Date: 16 April 2015
Our ref: 150205
Your ref: 15/00107/DISC

Planning consultation: Partial discharge of condition 16 of TWA/10/APP/01 - Relating to the Wendlebury Meads and Mansmoor Closes Site of Special Scientific Interest (SSSI)
Location: Oxford To Bicester Rail Link Buckingham Road Bicester

Objection – further information required

- Legend:**
- Proposed barn and access track
 - Access track
 - 1km buffer
 - Site of Special Scientific Interest (SSSI)
 - Ancient Semi-Natural Woodland (ASNW)
 - Local Wildlife Site (LWS)
 - Wildlife Trust Reserve (WTR)

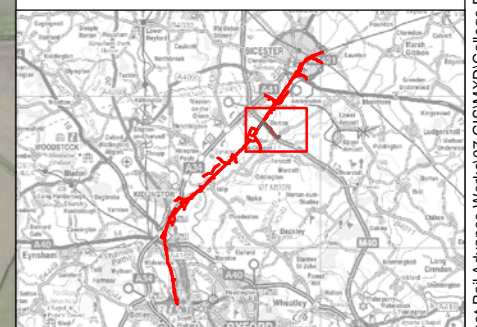
Figure 2a in the Wallingford Hydrosolutions Limited report shows the extent of the proposed barn and access track in light blue and an access track in red. The blue line is completely outside of the SSSI as explained in the report and method statement. However the red access track line encroaches on the SSSI by roughly 60m (using the scale on figure 2a). Can it be clarified if this is a mapping error, or if there is the intention for an access track to cross the SSSI?
